## 1. SSD10421 – Proposed Weigall Sports Complex, Sydney Grammar School – Request for Additional information

We have prepared this letter to address comments relating to parking and traffic engineering received from the Department of NSW Government Planning, Industry and Environment in relation to the subject project.

- Planning Industry & Environment – Letter Dated 19 May 2021

BUILDING 01
SPORTS FACILITIES BUILDING
GENERAL ARRANGEMENT PLAN
GROUND

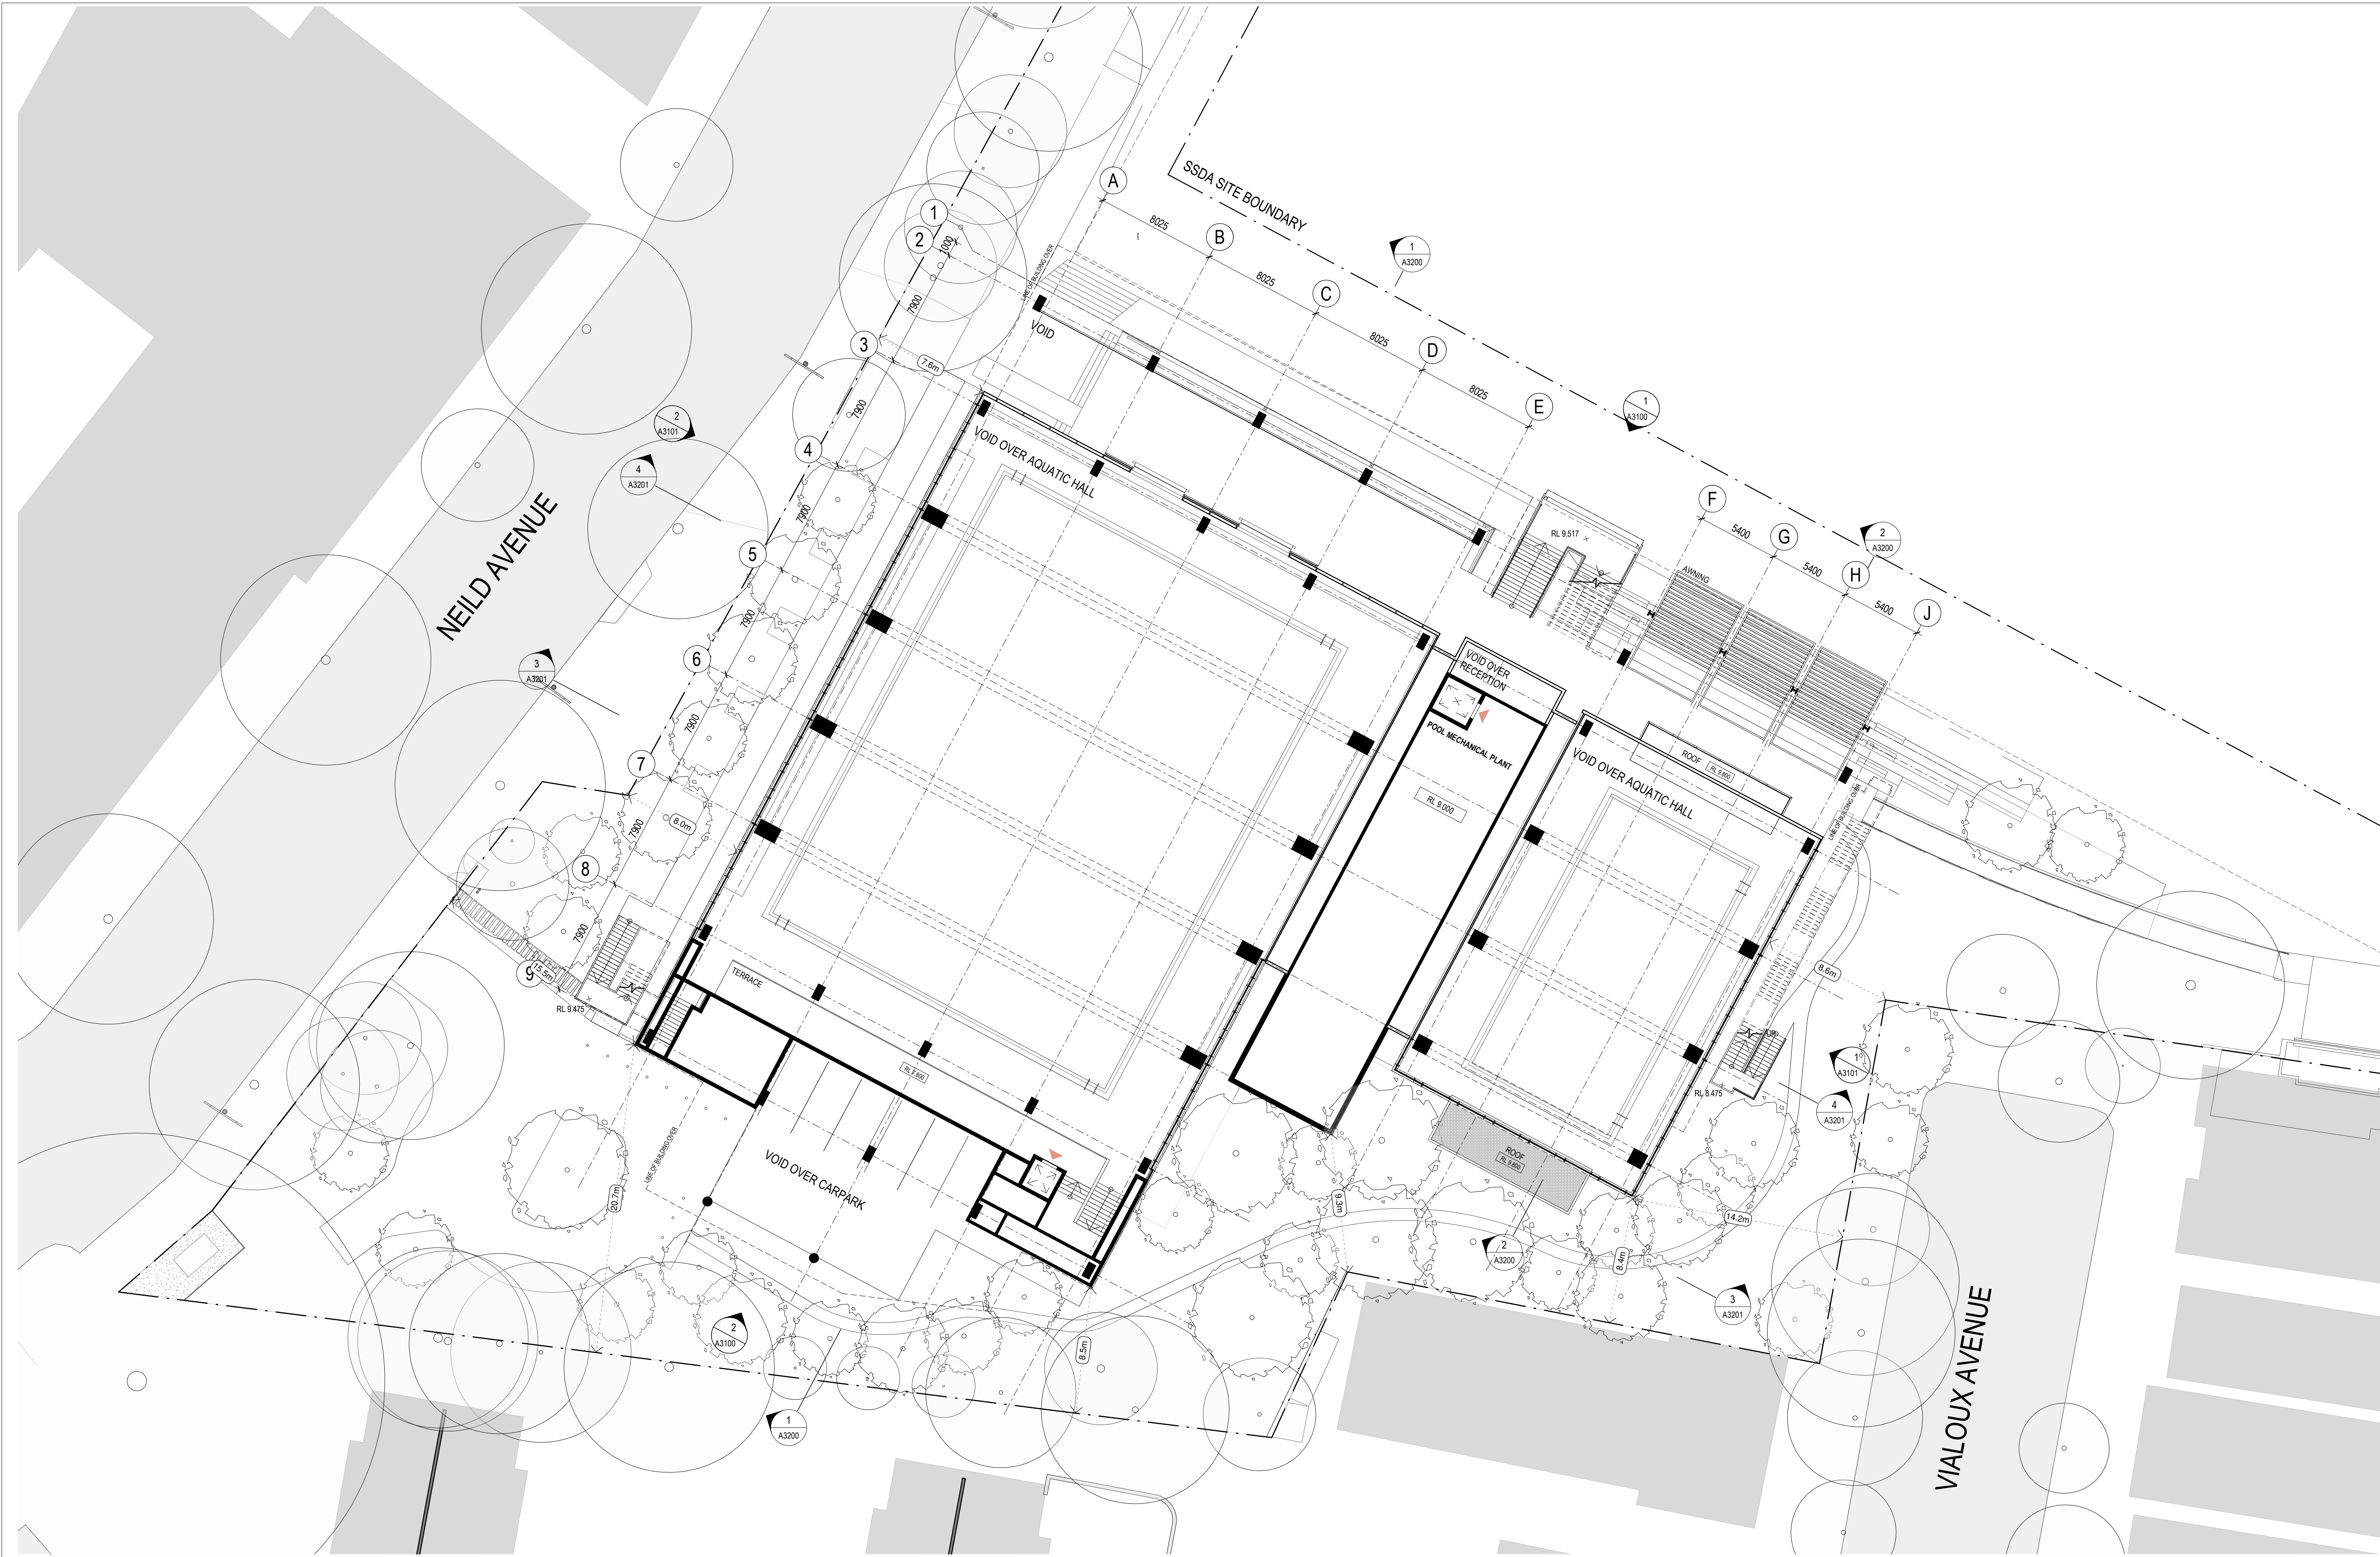
*Confirm what end of trip facilities will be made available to cyclists, with reference to the requirements of the Woollahra Development Control Plan 2015.*

The following requirements have been extracted from Section E1.6.1 of the Woollahra Development Control Plan 2015 in regard to the provision of end of trip facilities for non-residential land uses. The responses to the requirements are as below. The responses have been prepared in reference to the following architectural plan prepared by Allen Jack + Cottier Architects (see Attachment 1):

- *Building 01 Sports Facilities Building General Arrangement Plan Ground (Drawing No. A2101, Issue C, Dated 10 June 2021).*

The proposal involves the provision for two (2) all-day bicycle parking spaces for staff. While not stored individually, the two spaces are proposed to be located in one securely locked room. This is in accordance with the Planning Guidelines for Walking and Cycling and is considered sufficient for this development.

The proposal involves the provision of two (2) bicycle parking spaces for staff. Therefore, one (1) shower and one (1) change cubicle has been provided within the staff change rooms in line with the DCP requirements.

The proposal involves the provision of two (2) bicycle parking spaces for staff. Therefore, the proposal involves the provision of one (1) charging point within the staff bicycle storage area to accommodate potential electric bicycle users.
